SURREY COUNTY COUNCIL – RELEVANT REPRESENTATION OCTOBER 2023

GATWICK AIRPORT NORTHERN RUNWAY PROJECT

PINS Reference: - TR020005

Diagram 2.3.1: Model extent and key junctions

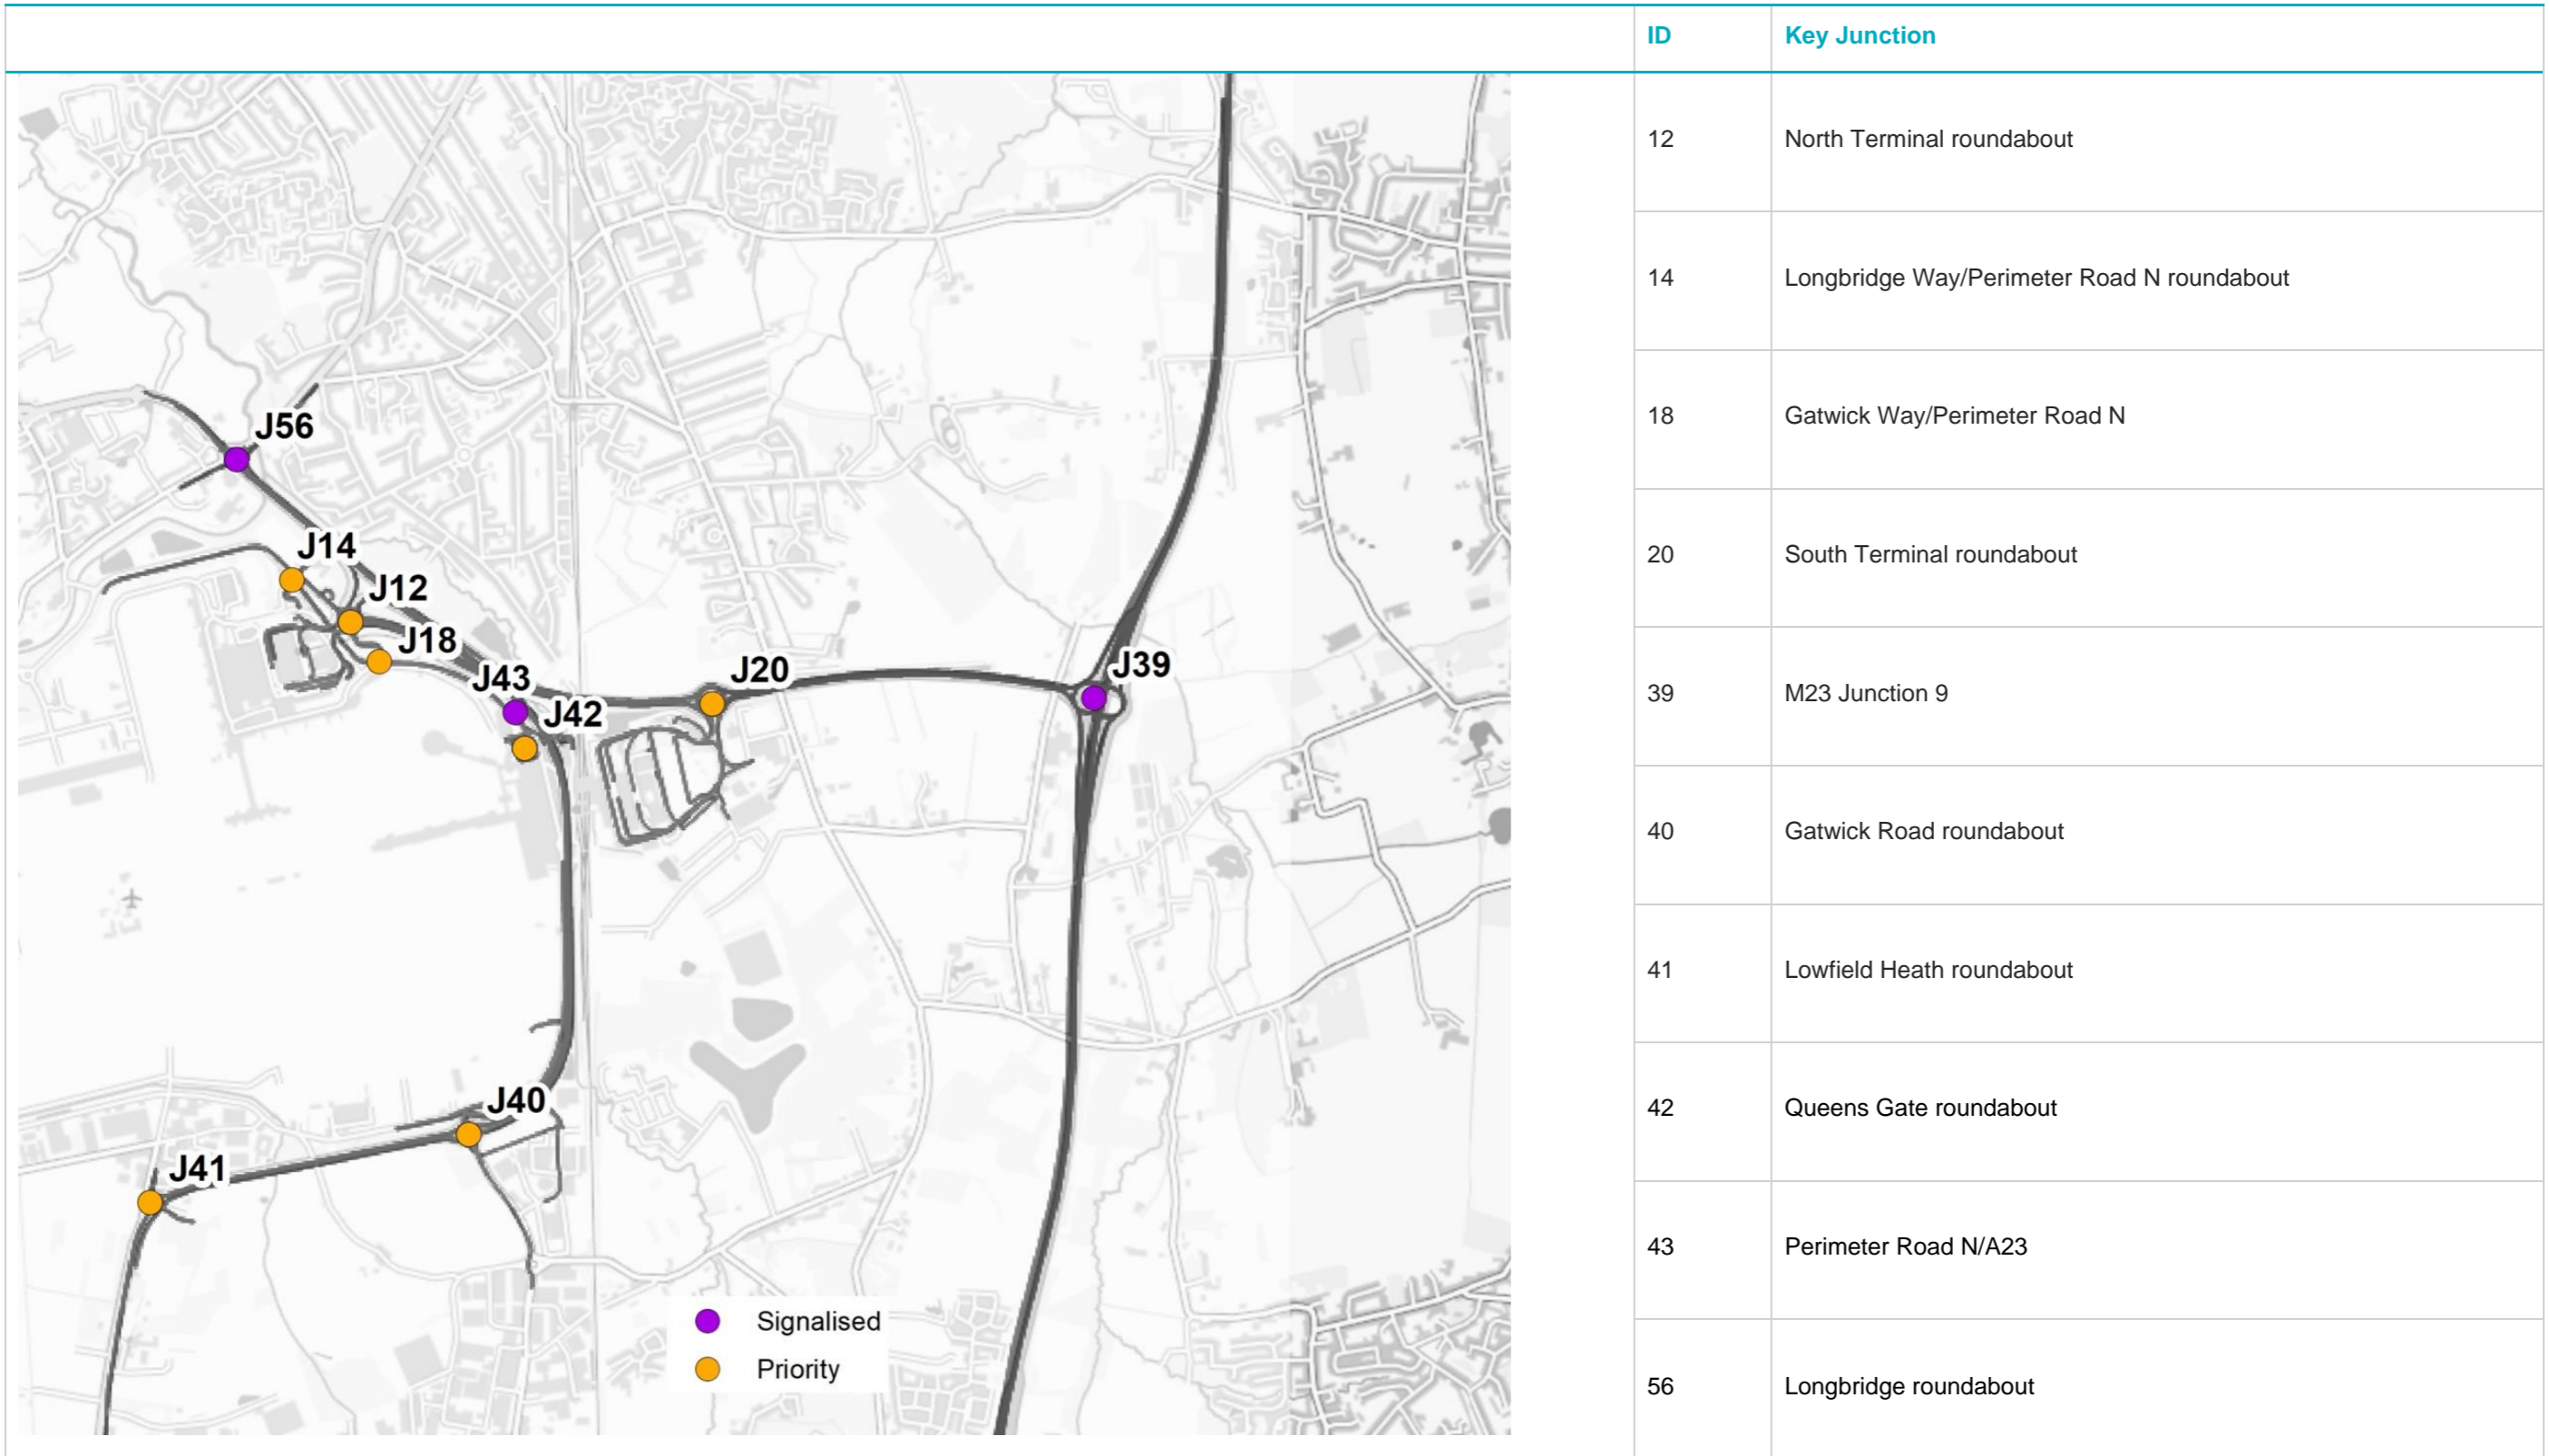
3.3 SCC is concerned that the extent of the VISSIM model includes only one junction in Surrey's network (Longbridge Roundabout), but its extent should be much larger. The model appears to be skewed towards the Crawley area, yet based on the distribution of airport traffic [APP-258 Diagram 12.3.2] the Horley area should feature more heavily.

3.4 SCC would like to see the microsimulation study area increased to cover more of its network. This will enable detailed investigation of the impact of the NRP on its local road network to be understood.
